Online Comment

Application H13-0292-25
Location Holly Tree House Fengate Moulton Chapel PE12 0XR
Proposal Proposed replacement dwelling

Name Greg Watkinson
Address Conservation Officer

**Plans, Section and Elevations
as existing**

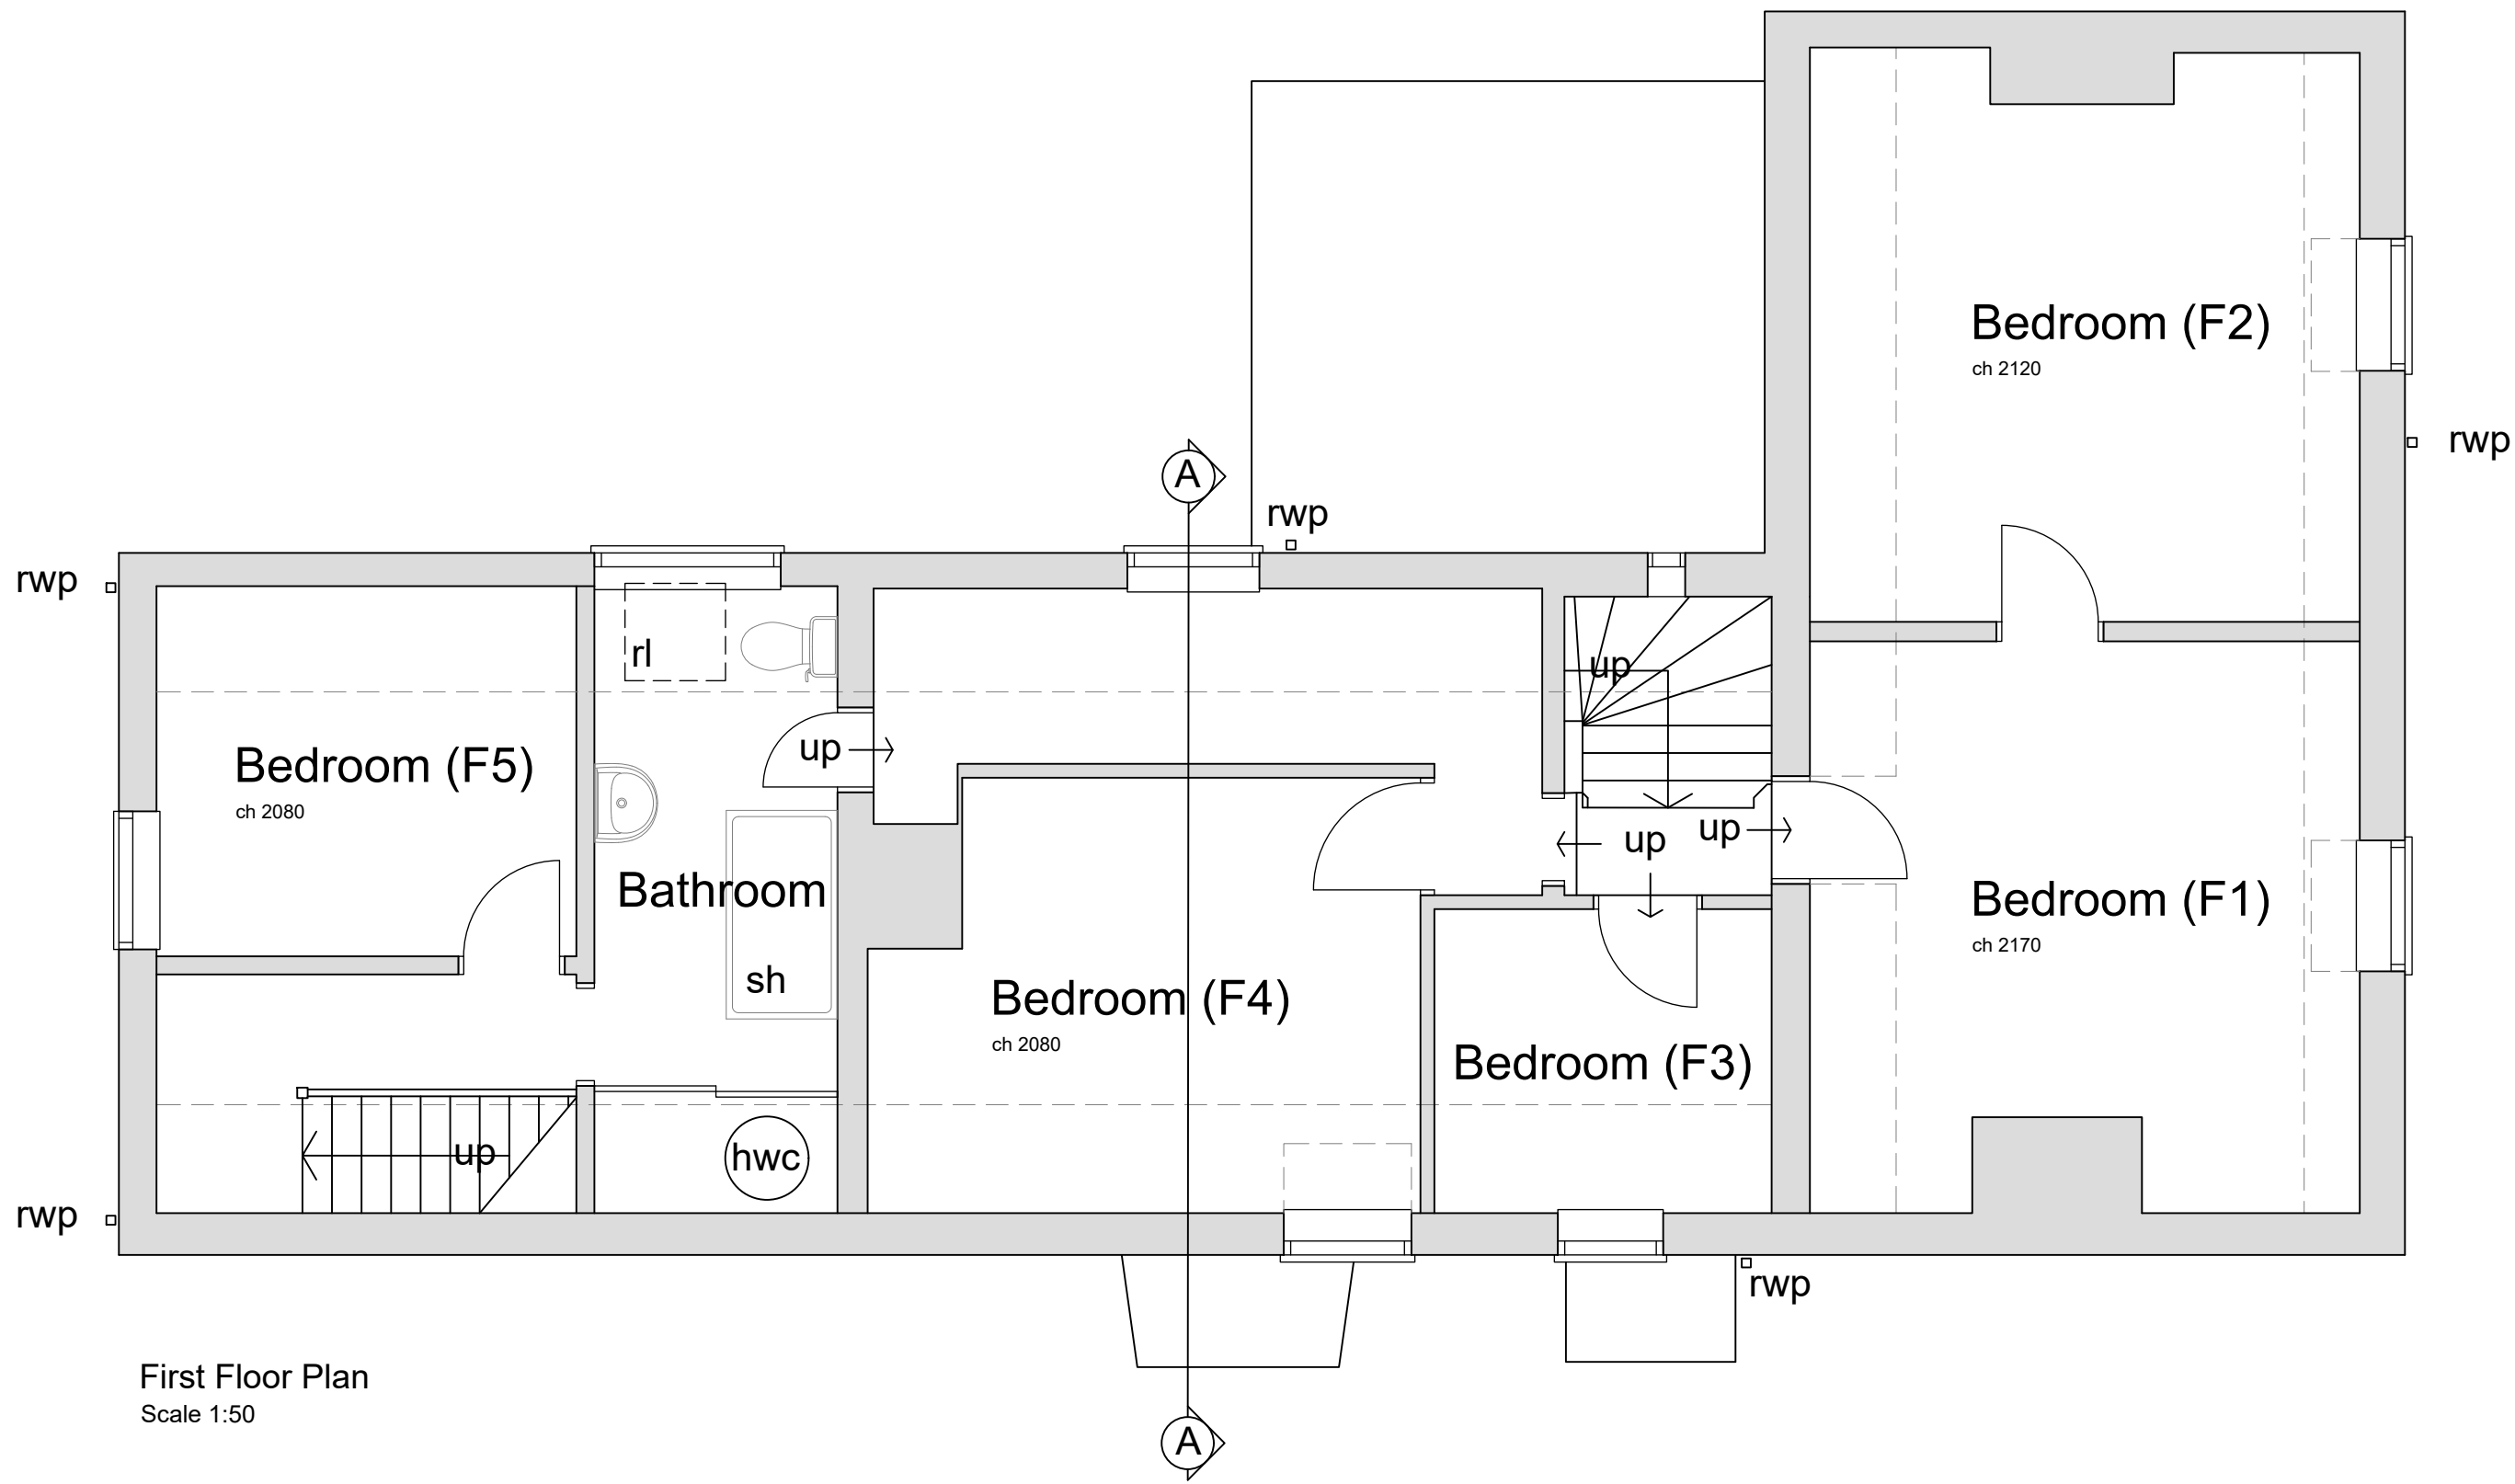
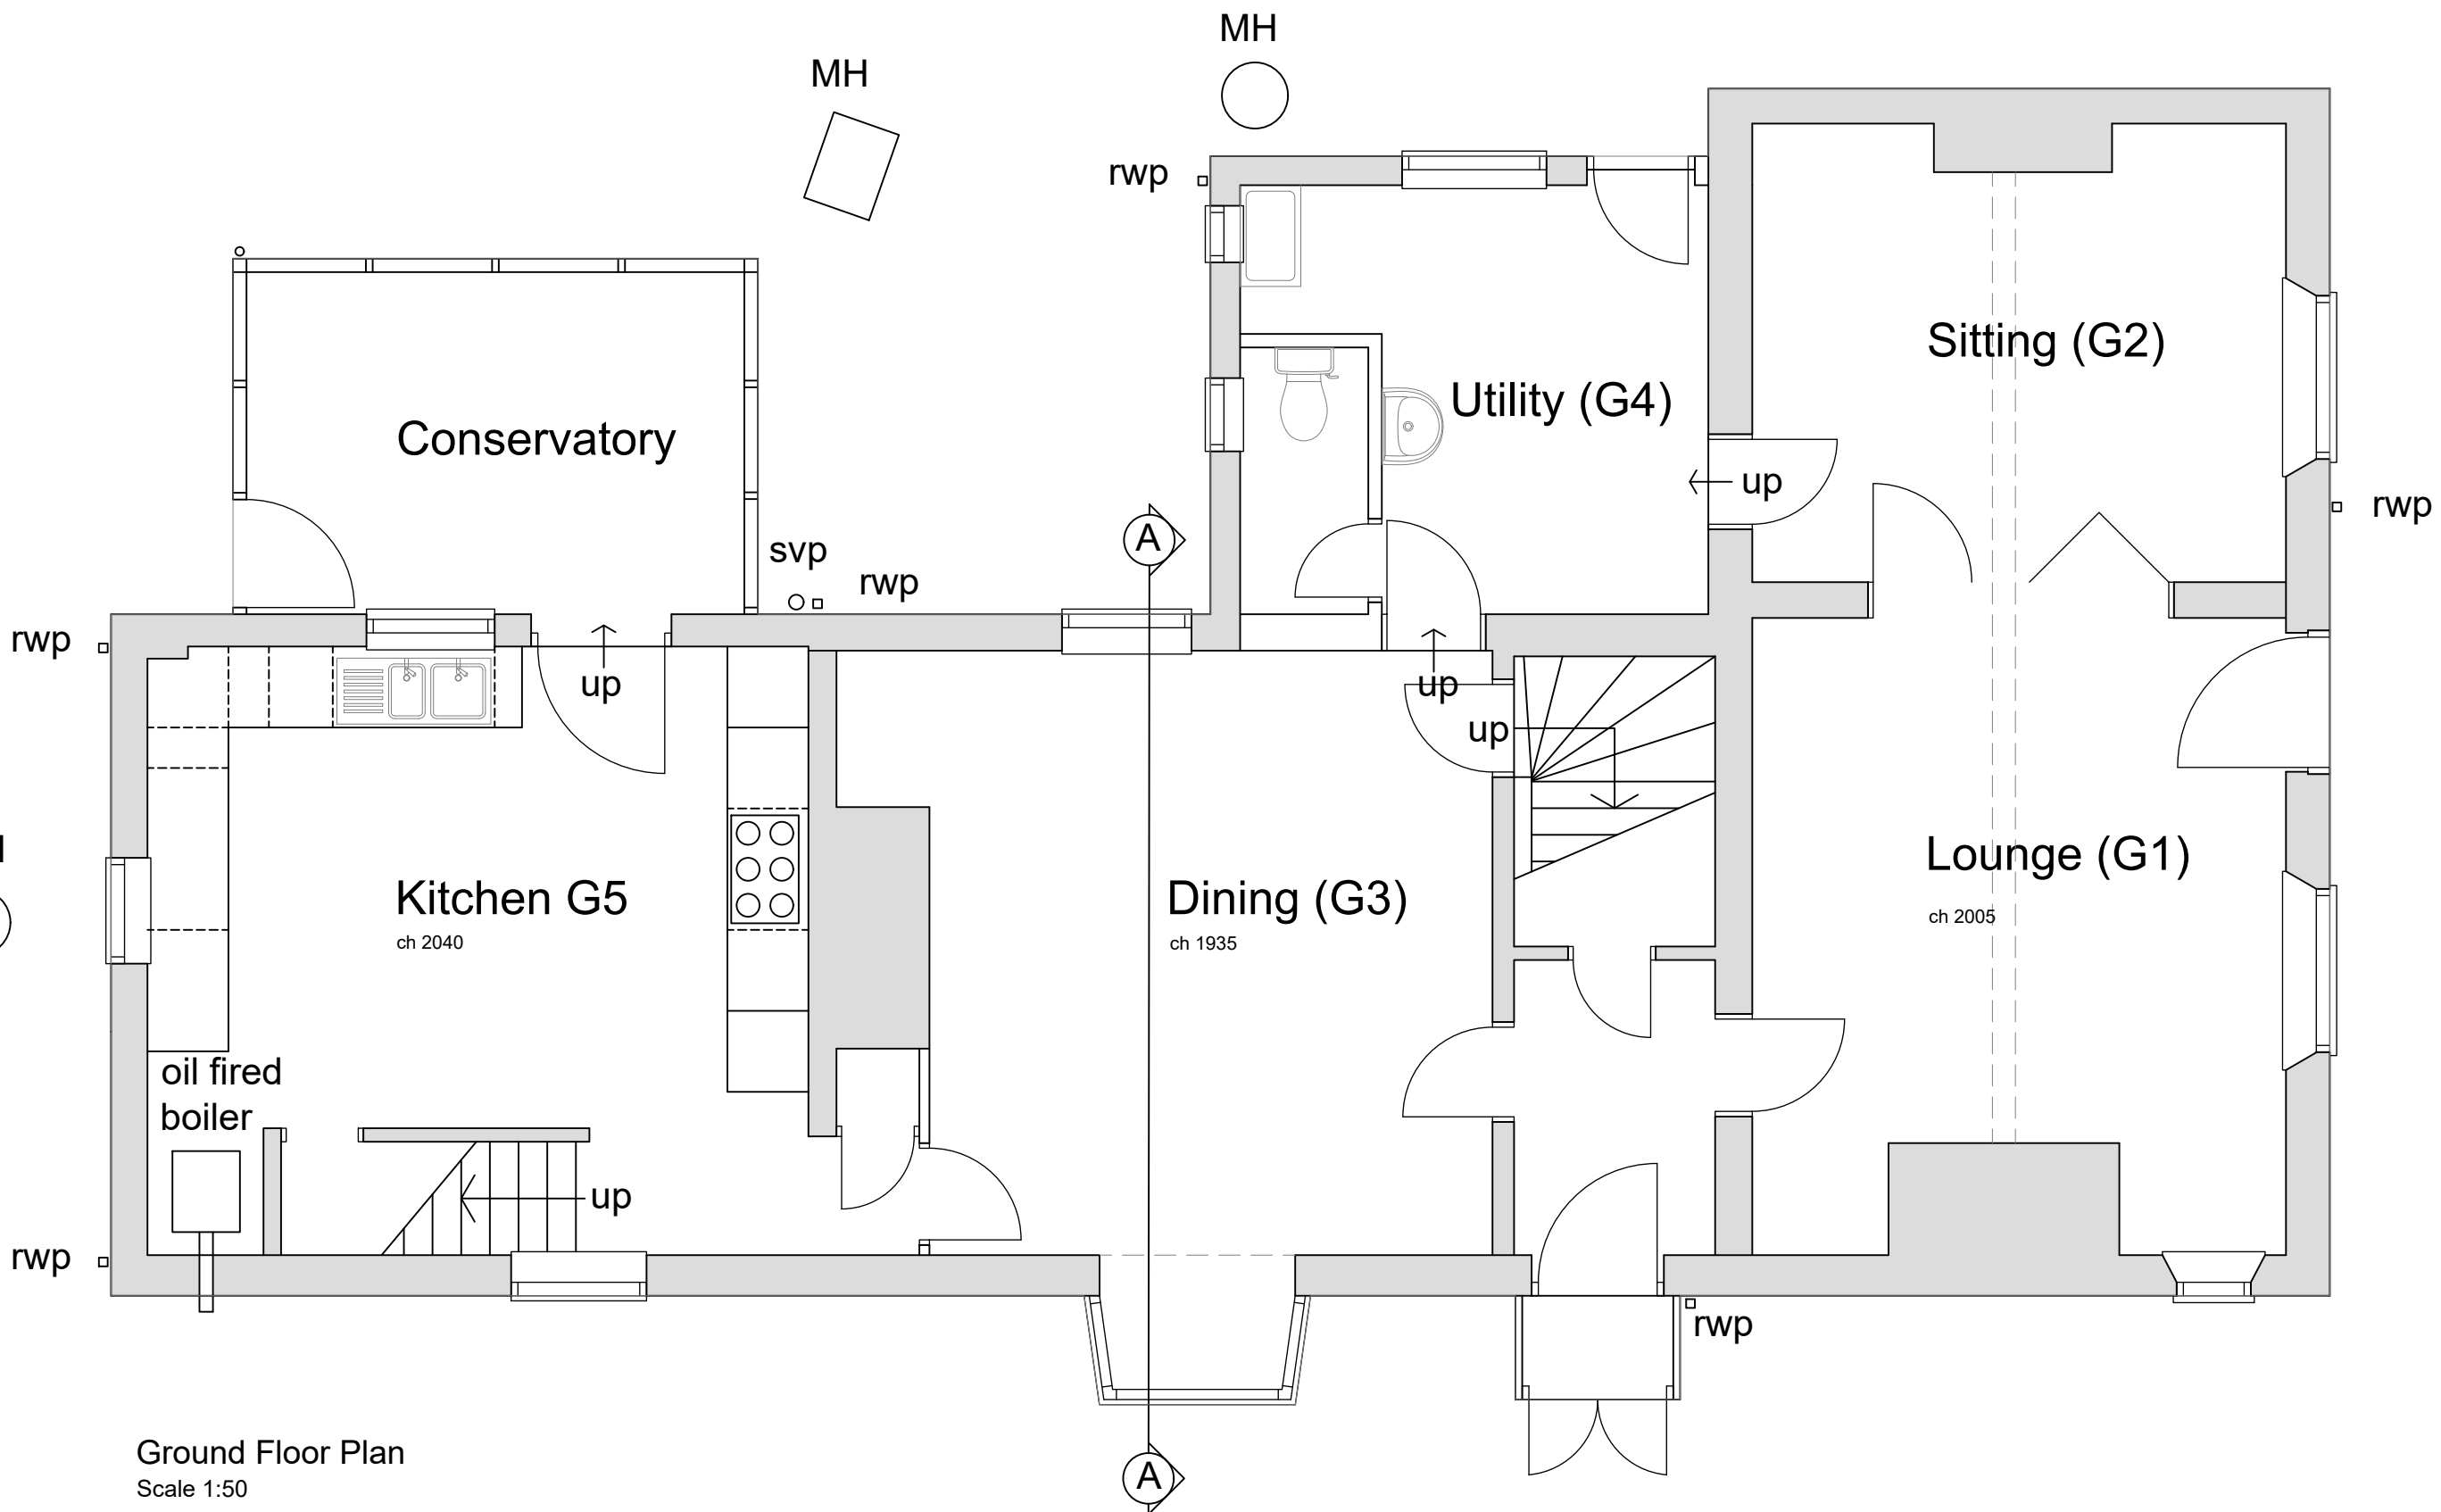
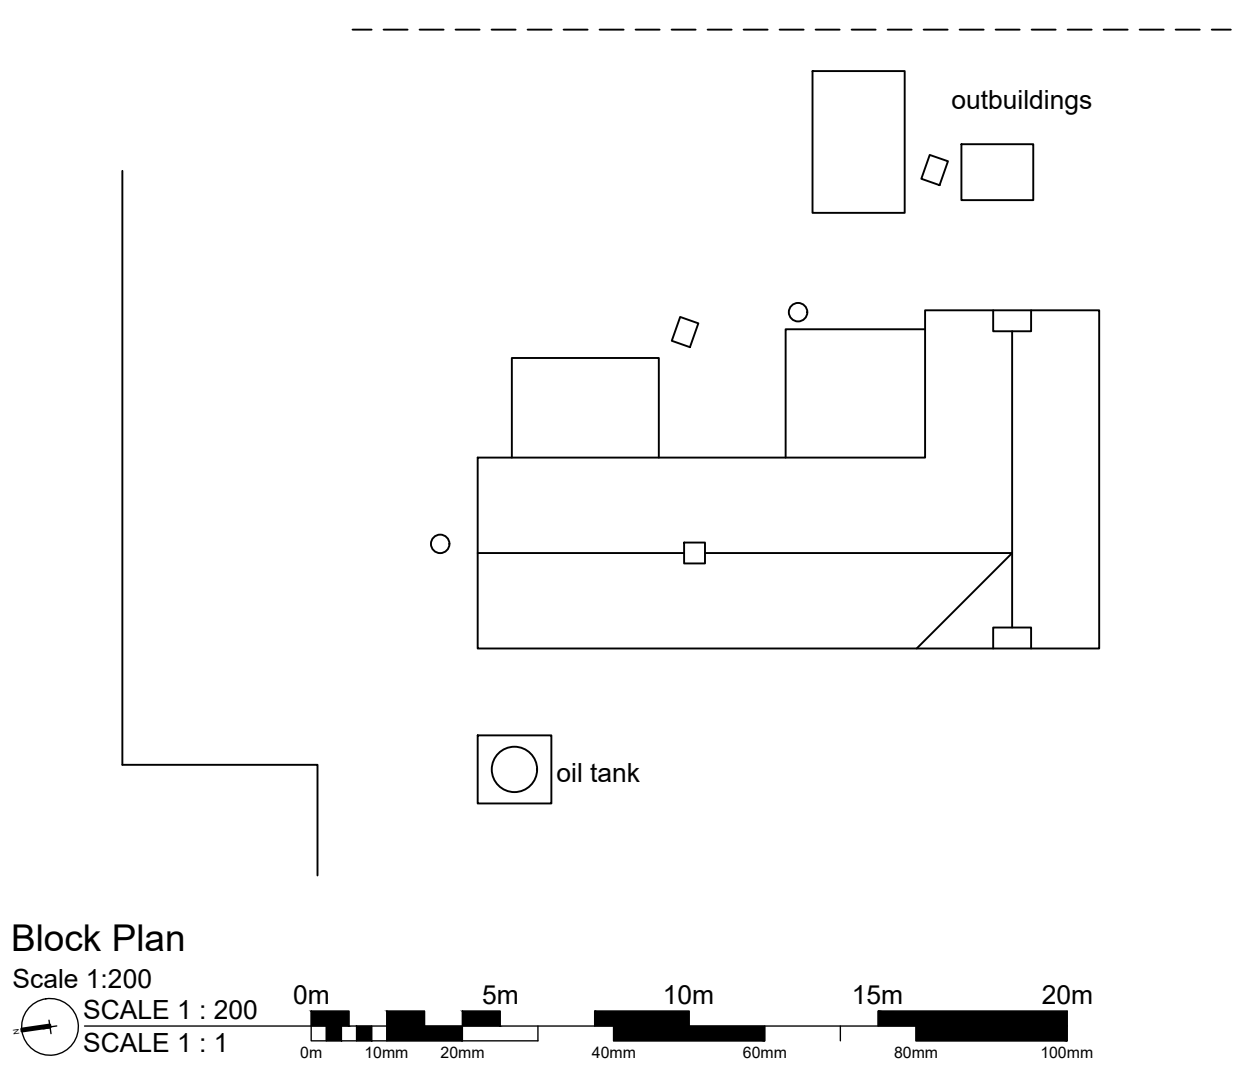
Moreover, this building retains some architectural value. Whilst it is clear it has been heavily altered over time, including with some harsh and non-sympathetic alterations, particularly in the form of cementitious coatings and various crude UPVC additions, the basic form and pattern of the building is one of a fairly traditional rural farmhouse with some interesting detail and significant potential for aesthetic improvement. Based upon P22 of the SELLP, I would therefore suggest that the extant property is of some architectural value, and it has not yet been shown that the structure is not capable of repair. Moreover, I am not satisfied that the proposed design is of a high enough quality to justify the loss of the extant structure. It is appreciated that the architect has gone to some lengths to replicate the traditional visage of the southern elevation, referencing the design of the extant. However, the remaining aspects of the other wing of the proposed structure appear relatively unsatisfying, giving the appearance of a relatively standard, somewhat slab-sided modern newbuild property.

In summary, I cannot support the application as proposed. I would expect that the applicant should be required to satisfactorily justify the reasoning behind why the original structure cannot be retained, and should the applicant be able to provide such satisfactory justification, the design should be reconsidered, particularly to ensure that the north-pointing 'wing' of the building is better treated to avoid appearing overbearing and featureless, particularly when viewed from the roadside and in the context of the adjacent heritage asset.
